Appeal Decision

Appeal Ref: APP/R5510/D/15/3015609

14 Airdrie Close, Hayes, Middlesex, UB4 9SR.

- The appeal is made under section 78 of the Town and Country Planning Act 1990 against a refusal to grant planning permission.
 - The appeal is made by Mr Arkadiusz Jachim against the decision of the Council of the London Borough of Hillingdon.
 - The application Ref 70406/APP/2014/3887, dated 25 November 2014, was refused by notice dated 20 January 2015.
 - The development proposed is a single storey ground floor side extension with a new porch.
-

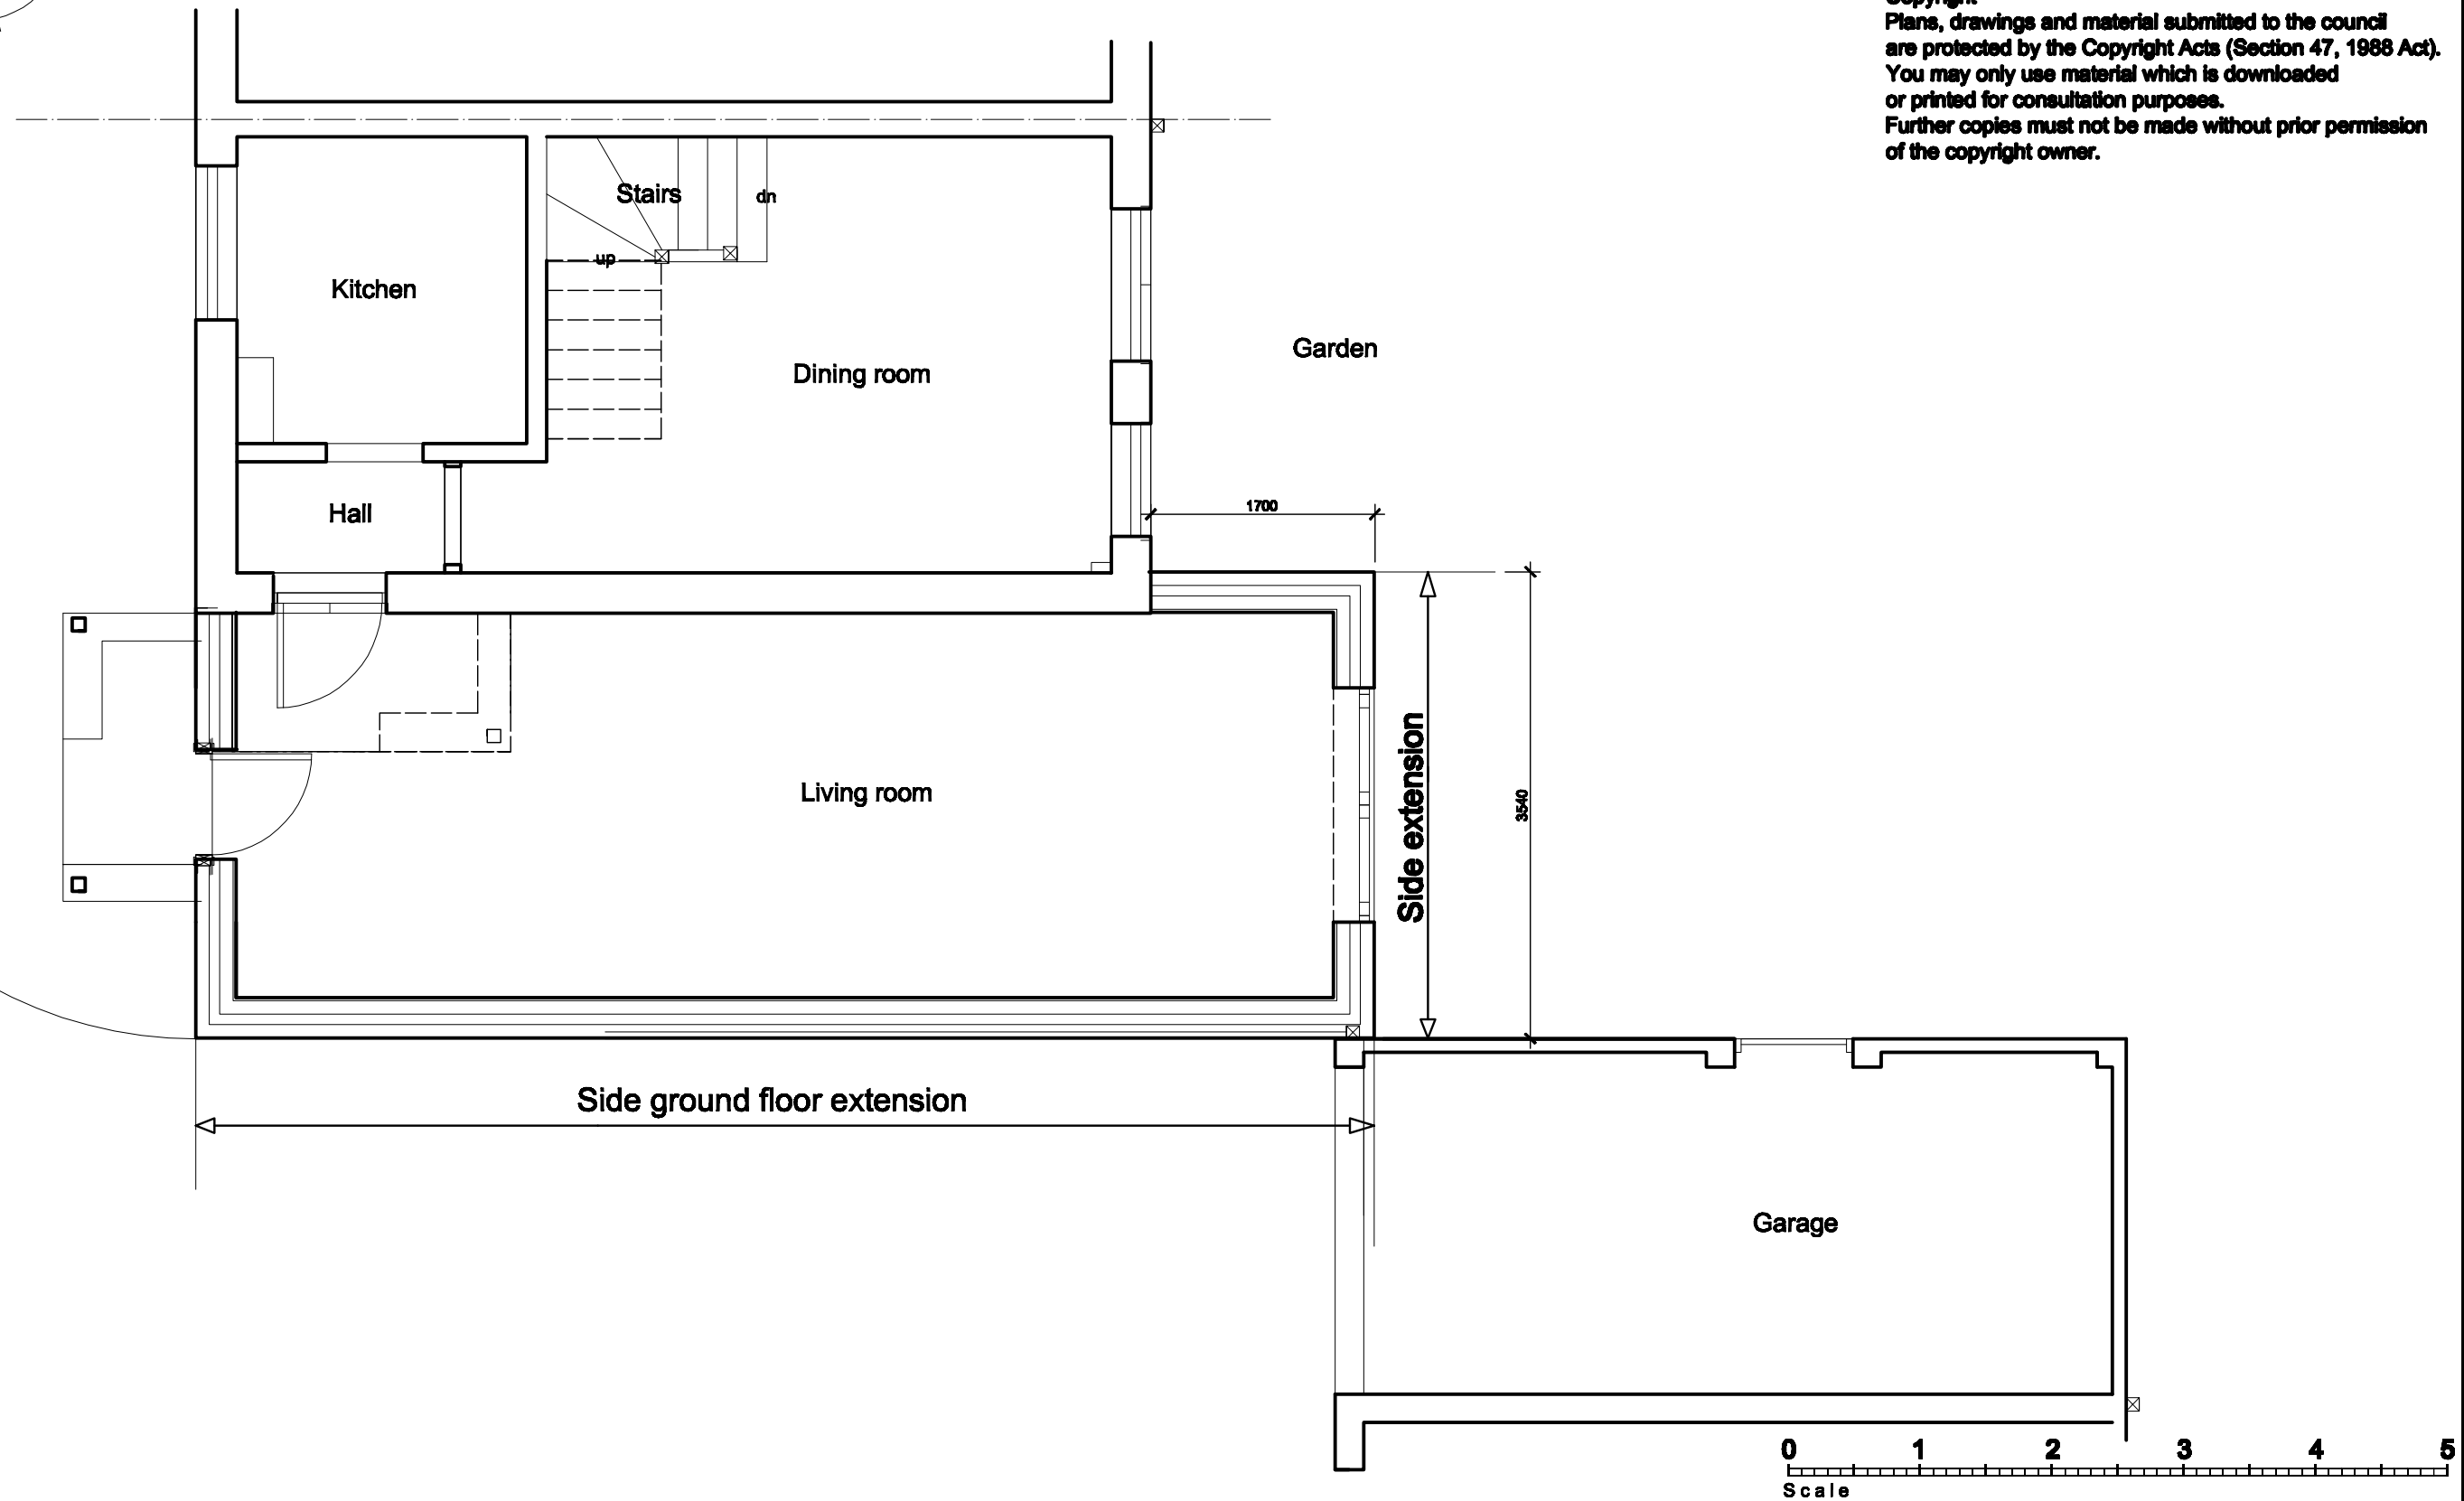
7. The proposed single storey extension would be in line with the front building line of the dwelling in accordance with the advice given in the Hillingdon Design and Accessibility Strategy Supplementary Planning Document: Residential Extensions (SPD). Contrary to the advice given in the SPD the extension would slightly exceed 2/3 of the width of the host dwelling and its height would slightly exceed 3.4 metres. However, the width of the extension would be comparable in width to a single garage and it would neatly fill the gap between the existing garage and the dwelling. In addition, the pitch of its hipped roof would respect that of the host dwelling and the adjacent garage building and it would logically sit immediately below the eaves line of the host dwelling. At the same time the proposed front porch would respect the siting, design and materials of the existing front porches within the estate.

8. Accordingly, whilst the proposed extension would not comply with some of the advice set out in the SPD, it would comply with the objectives of the advice; namely to ensure extensions respect, reflect and appear subservient to the host dwelling and the street scene.

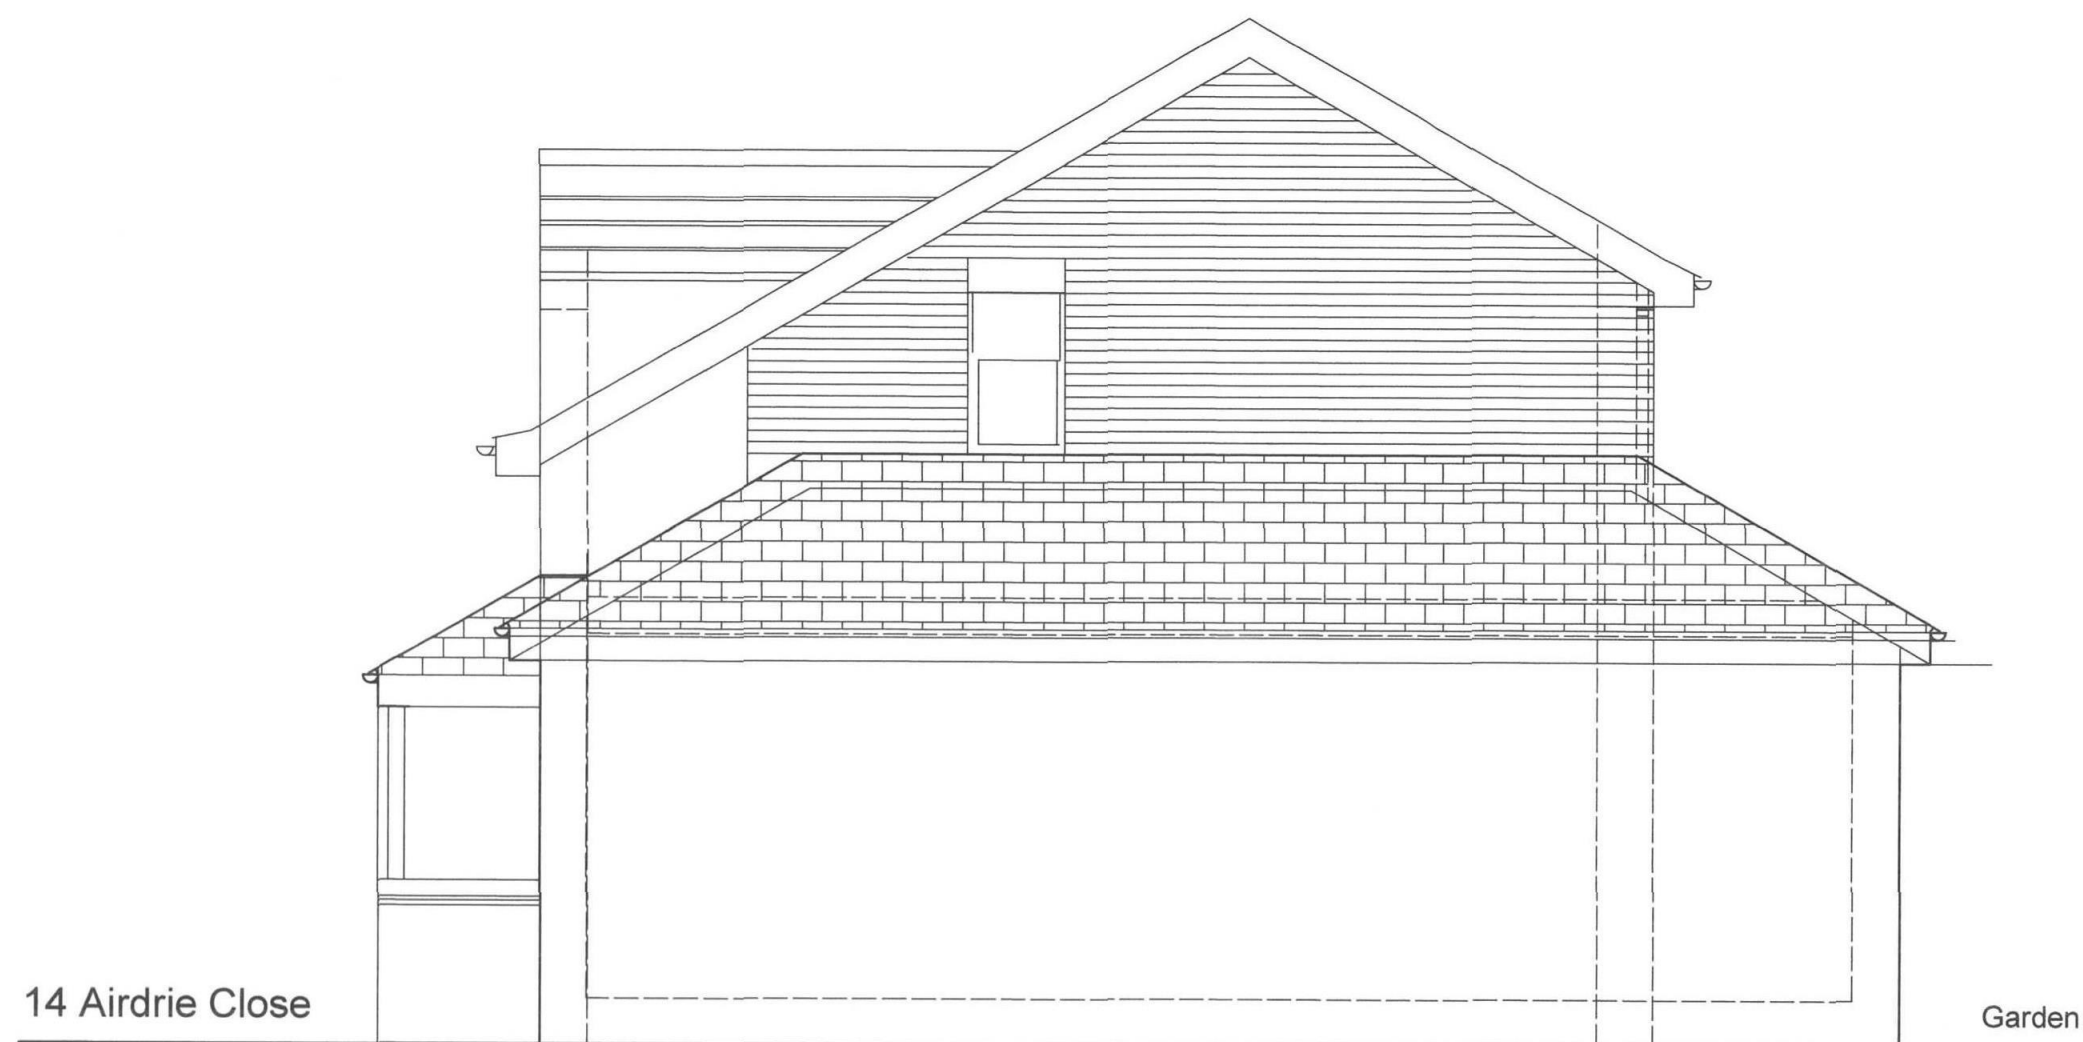
9. The proposed extension would be deeper than the host dwelling. However, it would be located in a discrete position at the end of the cul-de-sac where the side elevation would only be visible in very limited views. Where it could be seen the proposed extension would be set against and below the flank elevation of the host dwelling and it would sit comfortably between the host dwelling and the existing garage building.
